July 12, 2016

RE: Harnett County Land Use Existing Tank Application # 16-5-39075

SITE PLAN APPROVAL Garage
 DISTRICT RA-30 USE _____
 #BEDROOMS _____
0-30-14
 Zoning Administrator _____
 Date _____

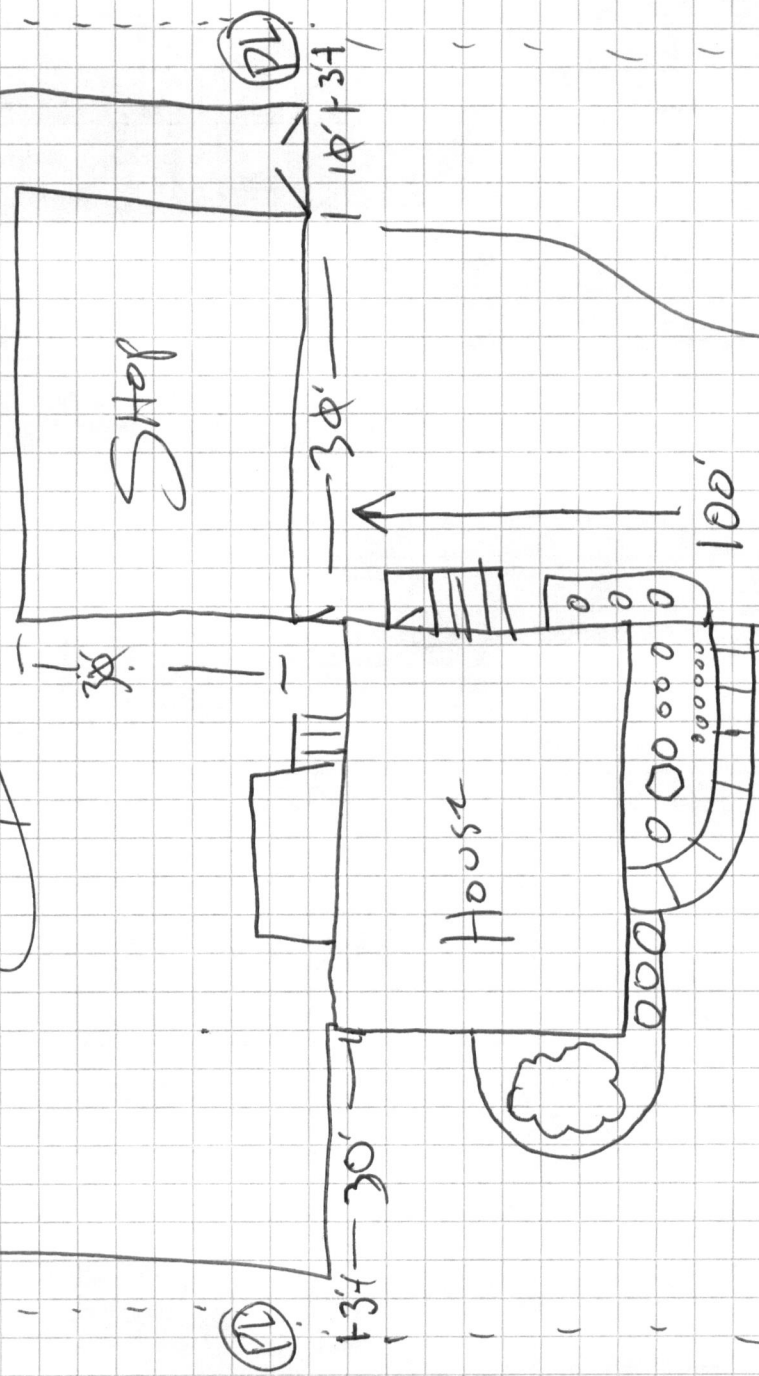
Based on the criteria set out in Title 15A, Subchapter 18A, of the North Carolina Administrative Code, Rules .1950, the evaluation indicated that the site is **UNSUITABLE** for the addition requested. Therefore, your request for an existing tank is **DENIED**. The site is denied based on the following:

- _____ **15A NCAC 18A.1950a {16} - Any swimming pool must be 15' from any part of septic system.**
- _____ **15A NCAC 18.1945{b} - Each lot shall have original septic system plus repair area.**
- X** **15A NCAC 18A.1950 {10} - Any building to be 5' from septic tank and/or from drain line.**
- _____ **15A NCAC 18A.1950{c} - Nitrification fields and repair areas shall not be located under paved areas or areas subject to vehicular traffic.**

Call me to discuss further in detail. Please revise your application at Central Permitting with either a smaller garage and/or change location. Your proposal puts the garage over your drain line. If you should have any questions or concerns I can be contacted Monday through Friday from 8am – 9am at 910-893-7547.
